Re: BP# 2017-00533_40 Dirigo Street

40 DIRIGO ST. – ADDITIONAL INFORMATION REQUESTED ON 5-25-17

40 Dirigo St. Floor Plan - Proposed Alterations

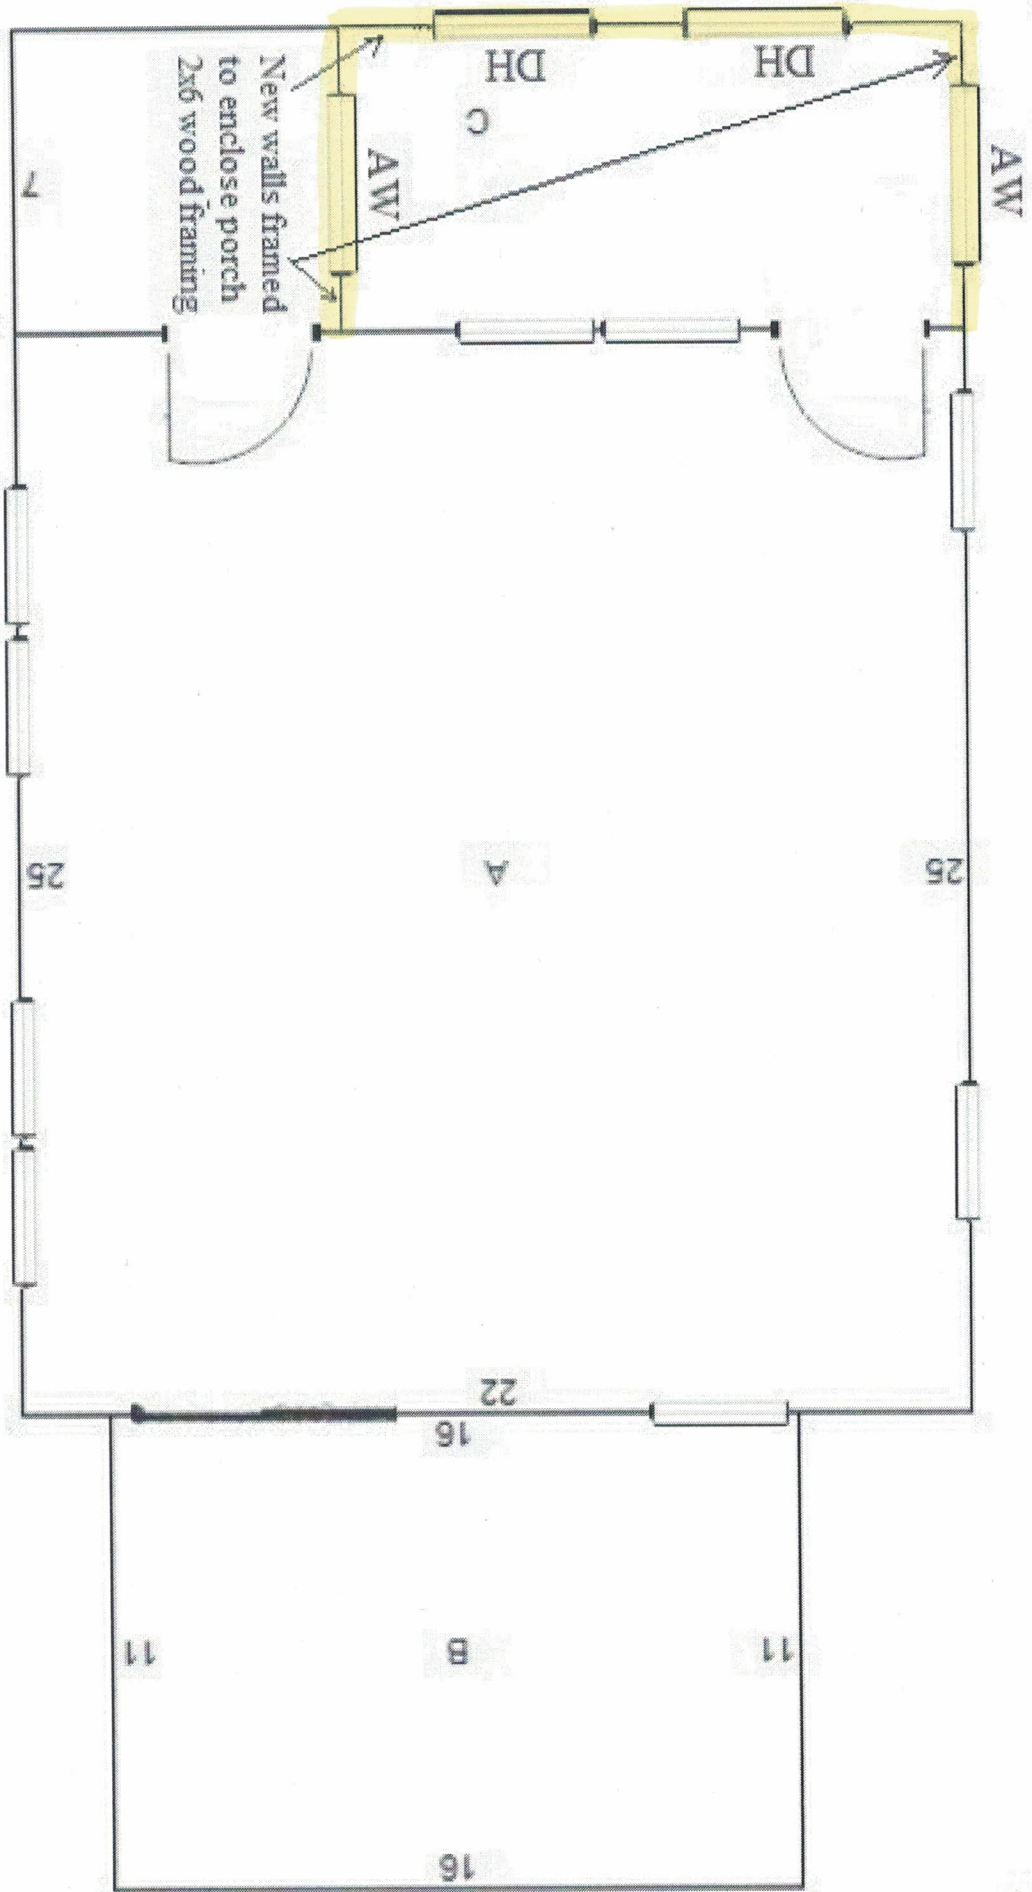
Please Provide the sizes of the windows and doors being added to the 3 season porch.

please provide the sizes of sheath that will be added top the floor and exterior walls

The window sizes on the front of the porch for the two double hung windows would be 34 1/4" x 53 1/4" to match the existing windows on the first floor of the home. The two awning windows would be 17 1/2" x 47 1/2".

The porch floor is pre-existing (it is a fully covered front porch with the ceiling being part of the currently existing roof). I want to frame in above the pre-existing vinyl sided 2'x6' railing/knee walls with 2 x 6 lumber and add sheathing, windows and vinyl siding to match existing. The sheathing I would like to use for the existing walls would be 15/32" x 4' x 8' Douglas Fir plywood.
